EL PASO COUNTY

Subject: Sterling Ranch Filing No. 2 Final Plat, Review #3 (SF-20-015)

**Sterling Ranch Filing No. 2
Final Plat Review**

FINAL PLAT
STERLING RANCH FILING NO. 2
JOB NO. 25188.01
9/22/2021
SHEET 5 OF 6
FILE NO. SF-20-015

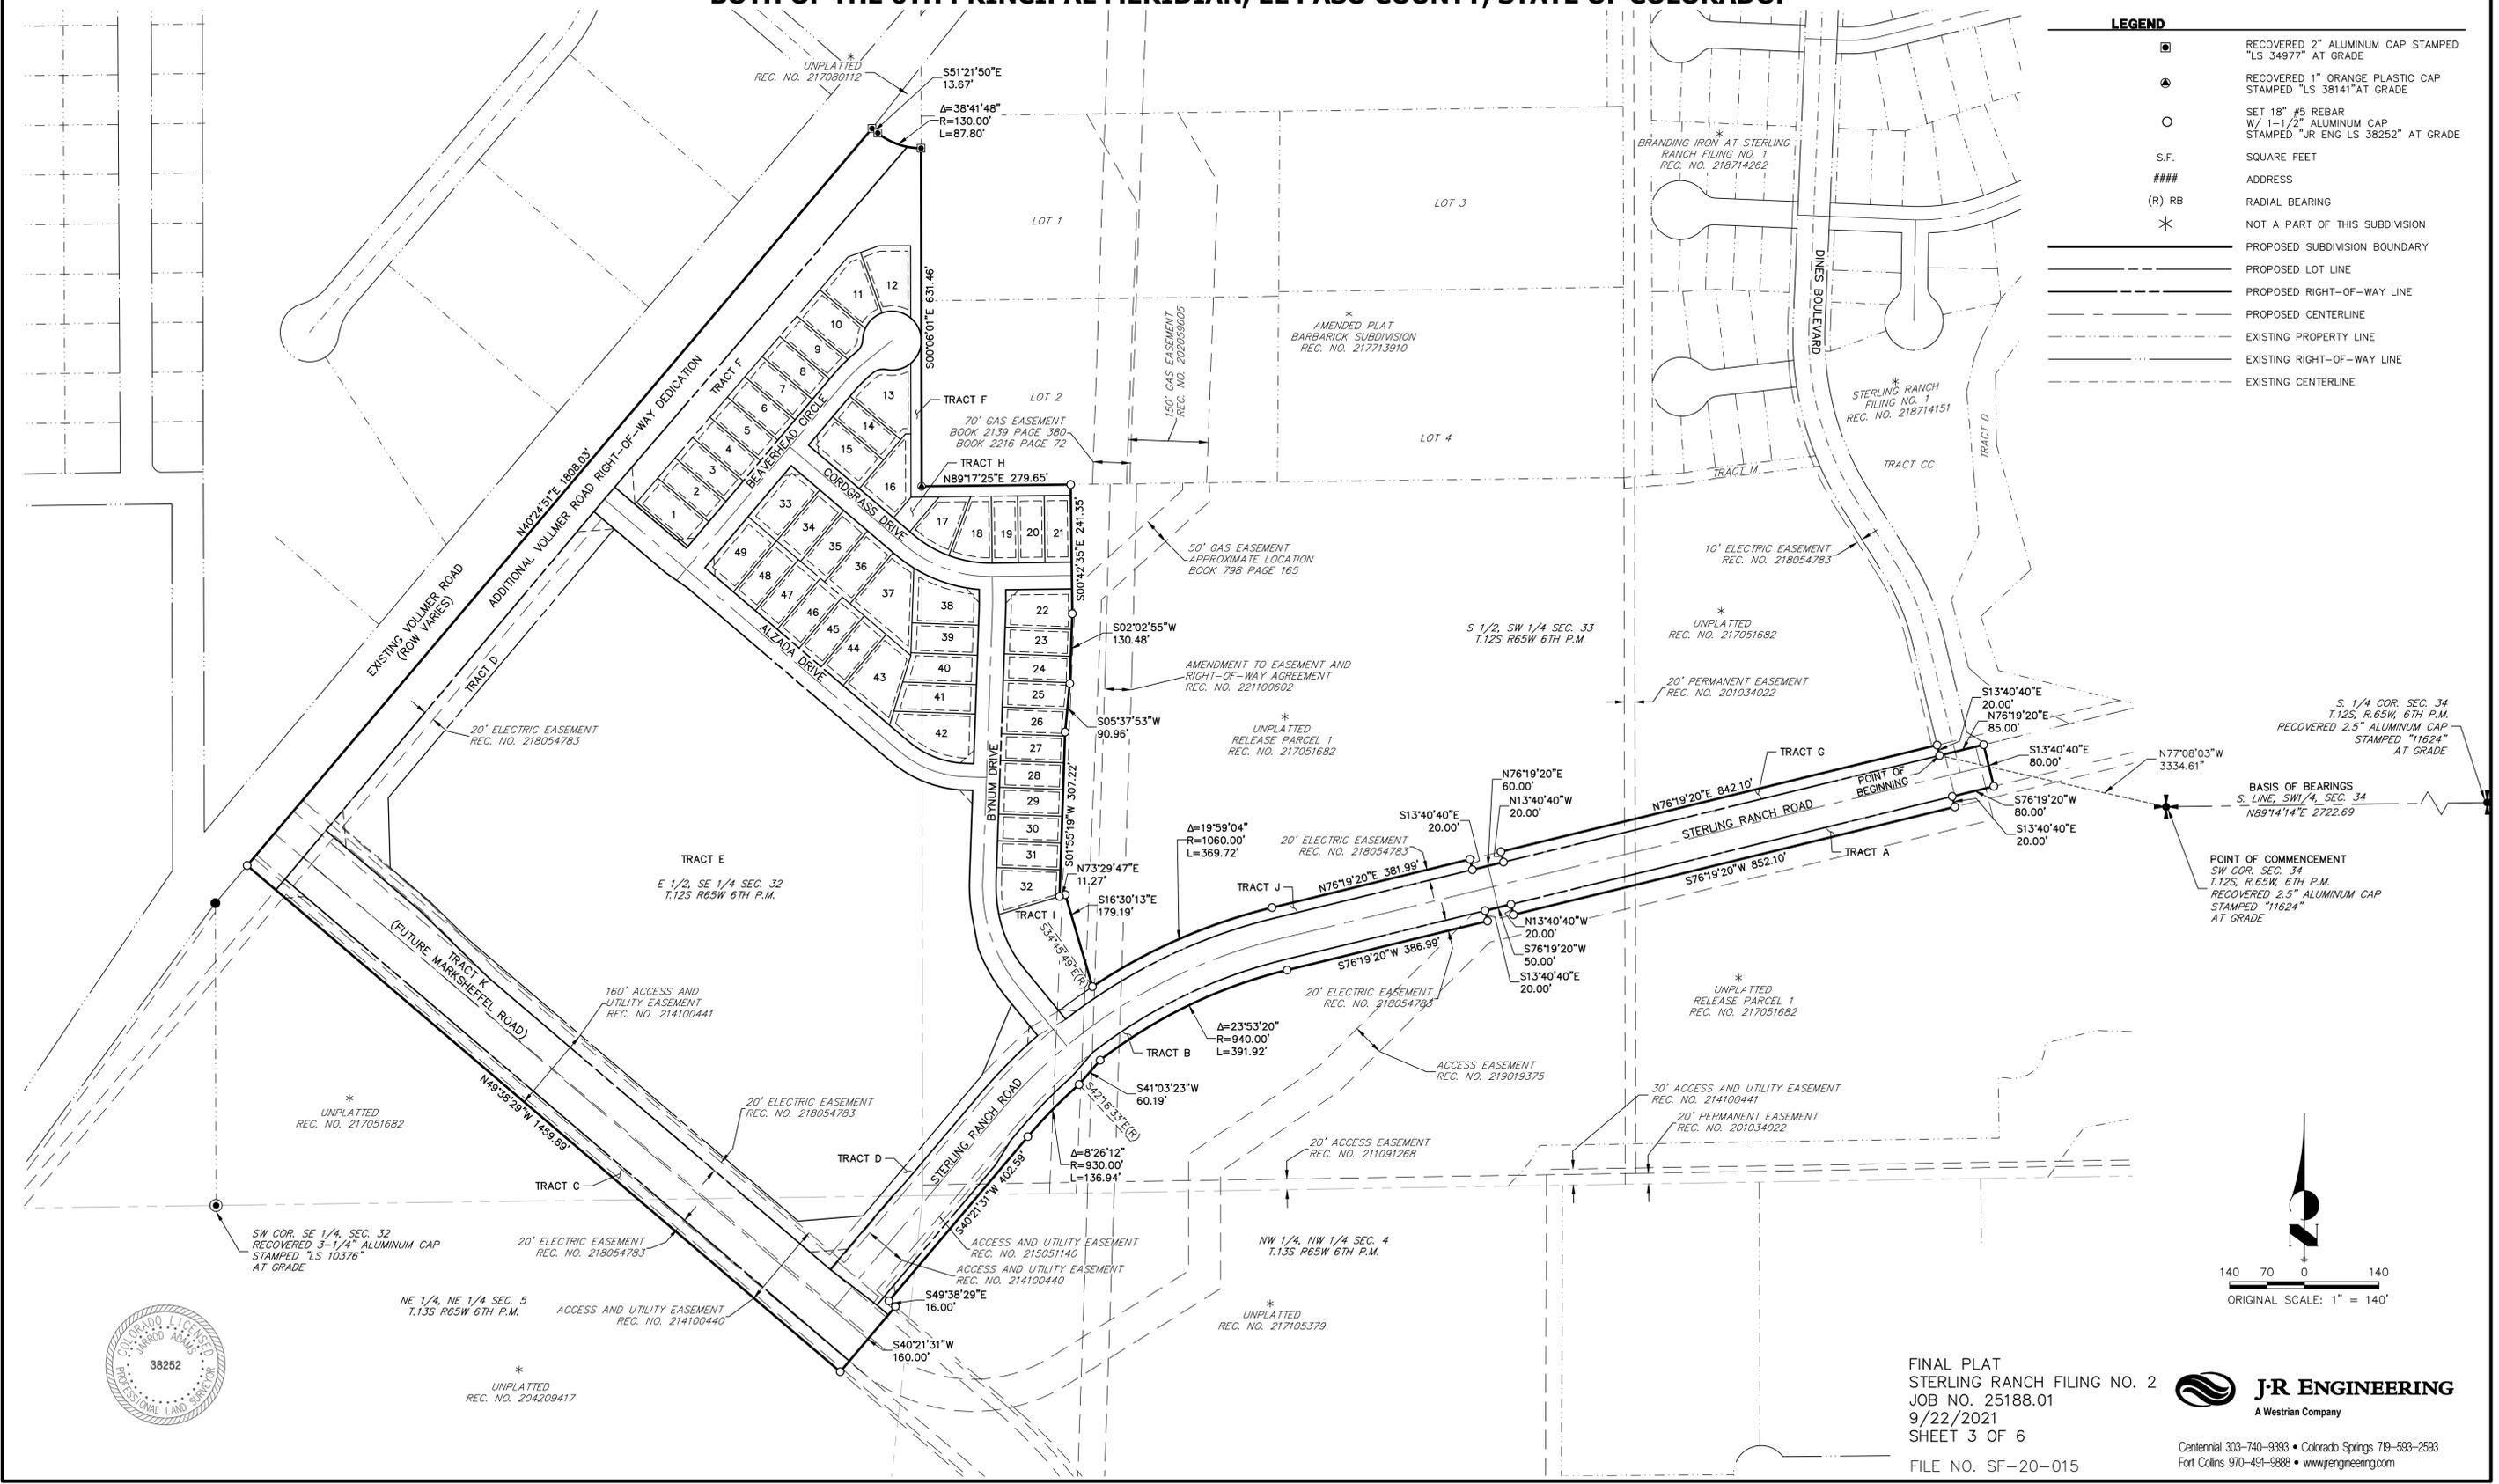
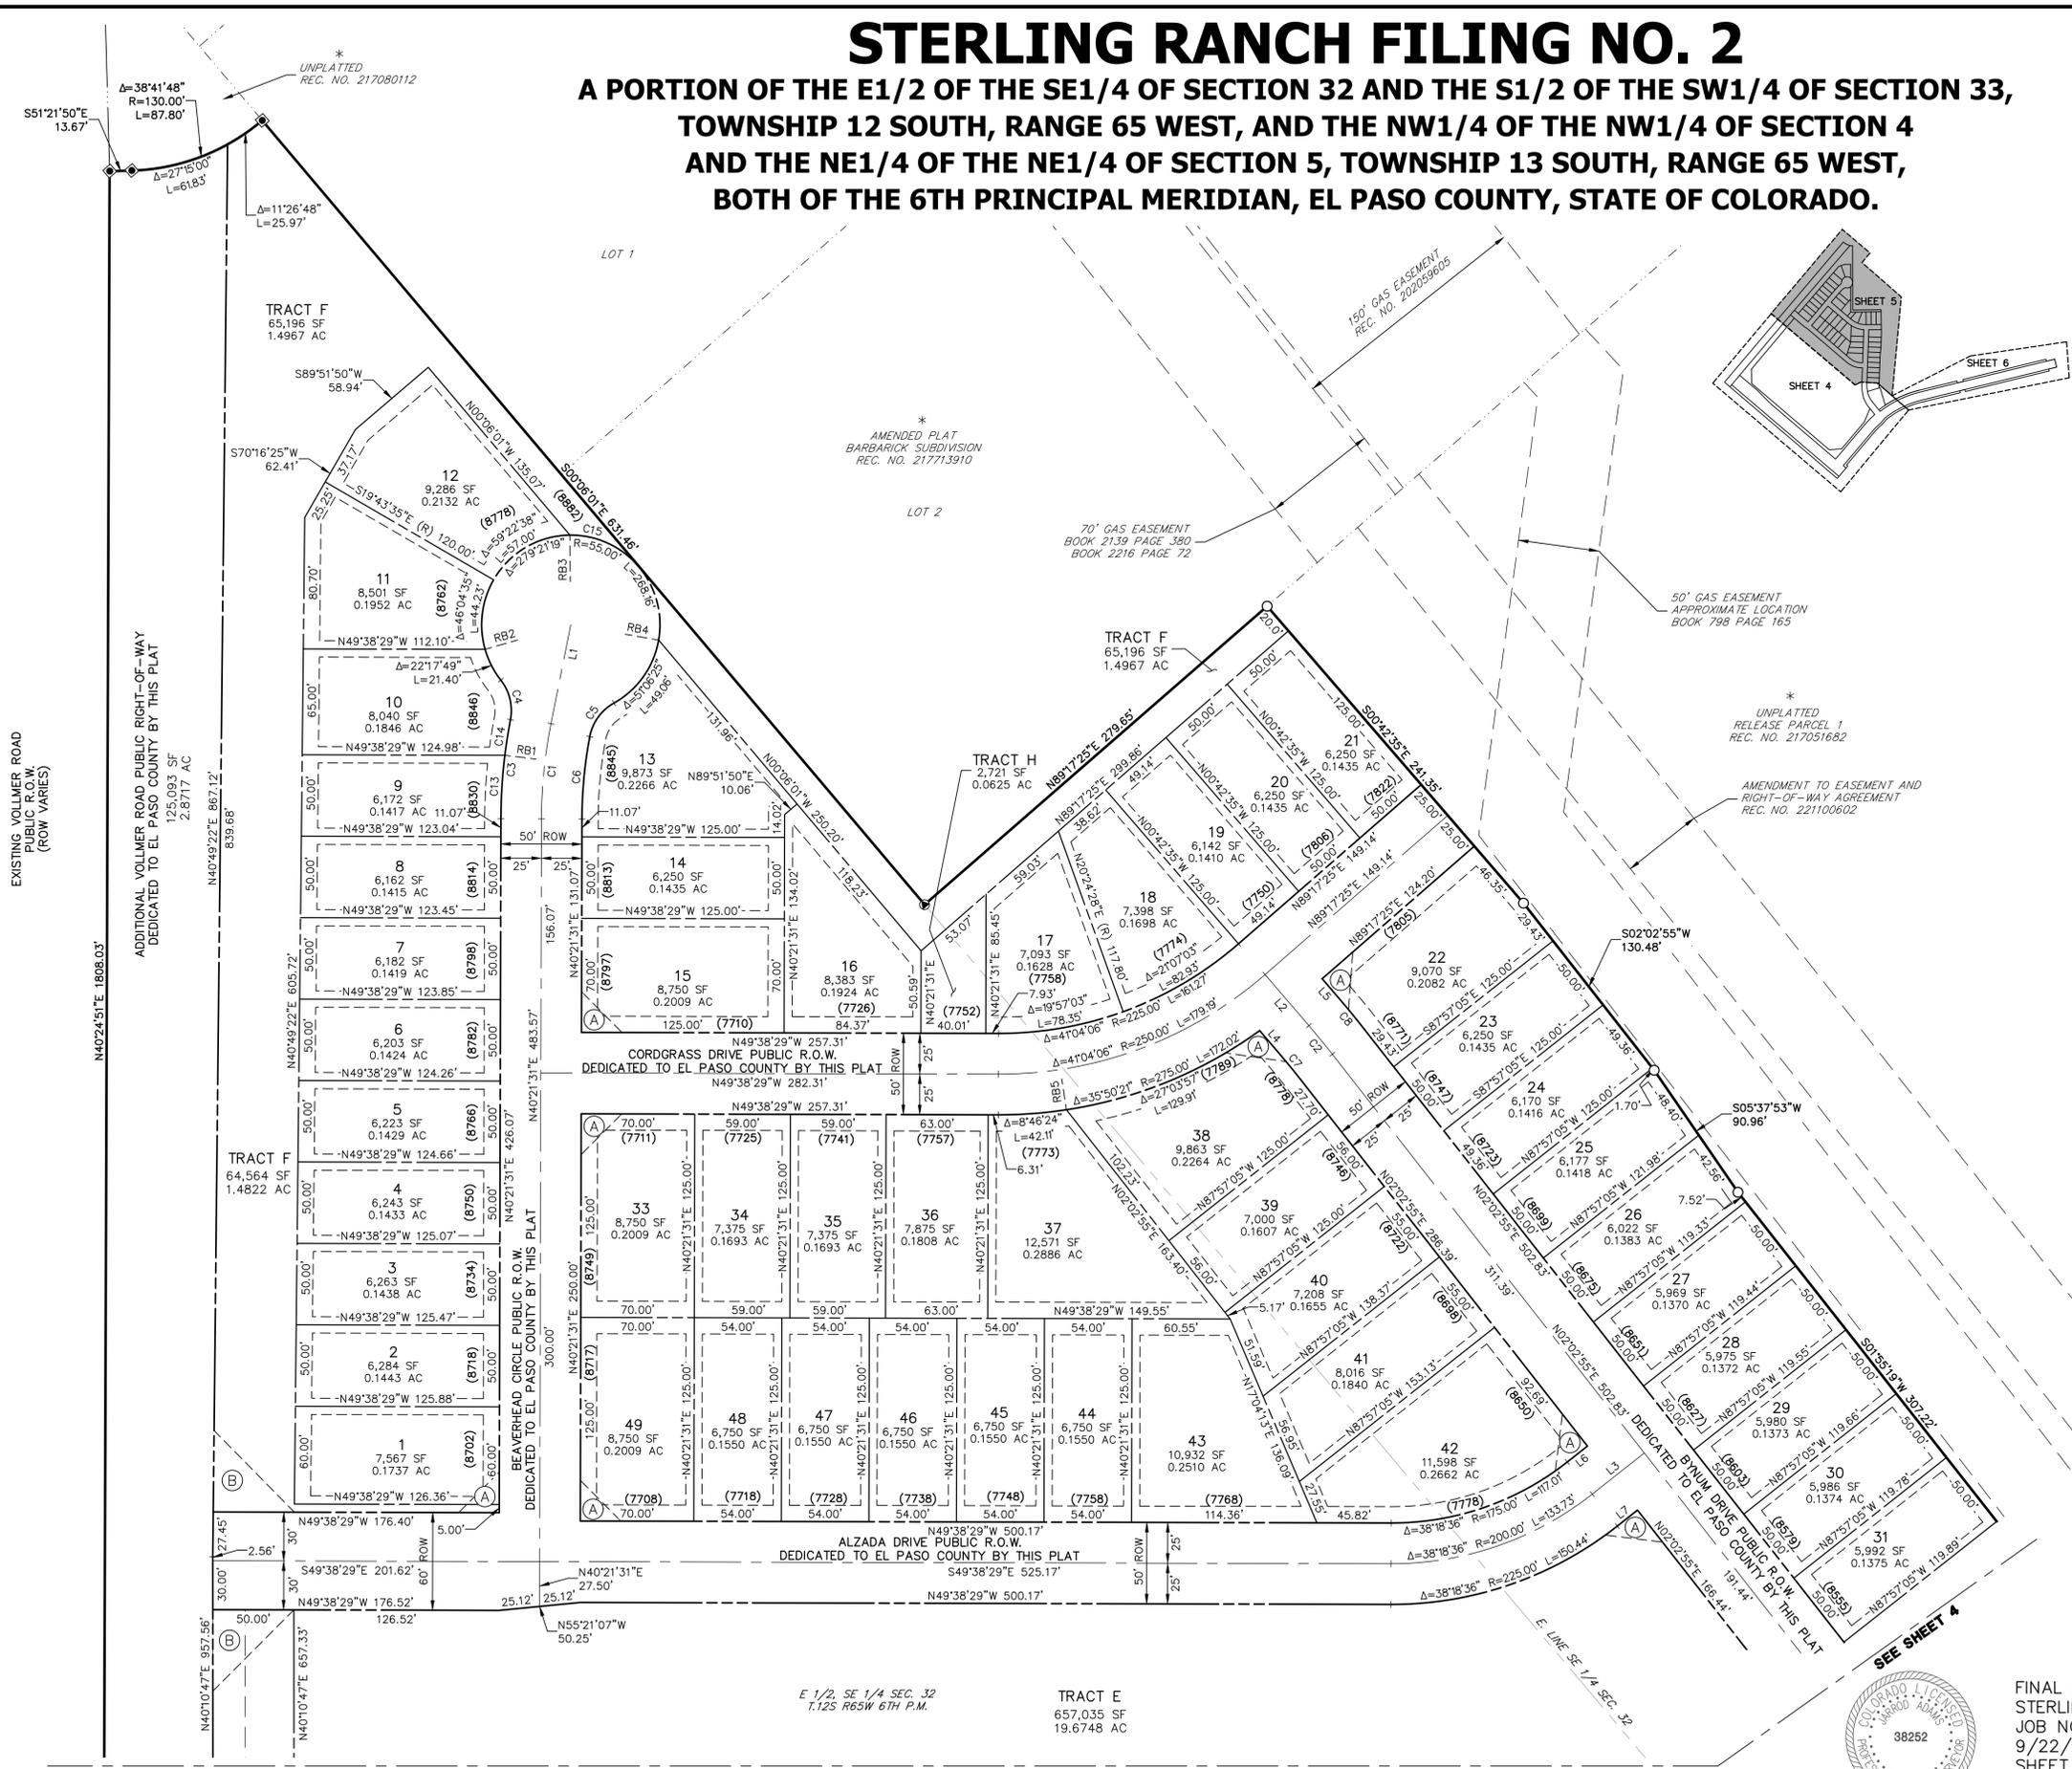
At this time, El Paso County Parks recommends that the applicant address the 25' trail easement located along the north side of Marksheffel Road, as recommended to and endorsed by the Park Advisory Board in February 2018. The trail easement is not shown on the submitted Final Plat, nor is it included in the Final Plat General Notes section. The additional 5' crusher fine trail is not depicted in the submitted Landscape Plans. These recommendations are highlighted below.

Recommend to the Planning Commission and the Board of County Commissioners that approval of Sterling Ranch Filing No. 2 Final Plat includes the following conditions: (1) recommend the developer install a 5-foot wide gravel trail adjacent the sidewalk along Marksheffel Road; (2) show on the Final Plat and dedicate to El Paso County a 25-foot trail easement along the north side of Marksheffel Road that allows for public access, as well as maintenance by El Paso County of the western branch of the Sand Creek Primary Regional Trail; (3) require fees in lieu of land dedication for regional park purposes in the amount of **\$22,883 (updated 07/16/2020)** and urban park fees in the amount of **\$14,455 (updated 07/16/2020)**.”
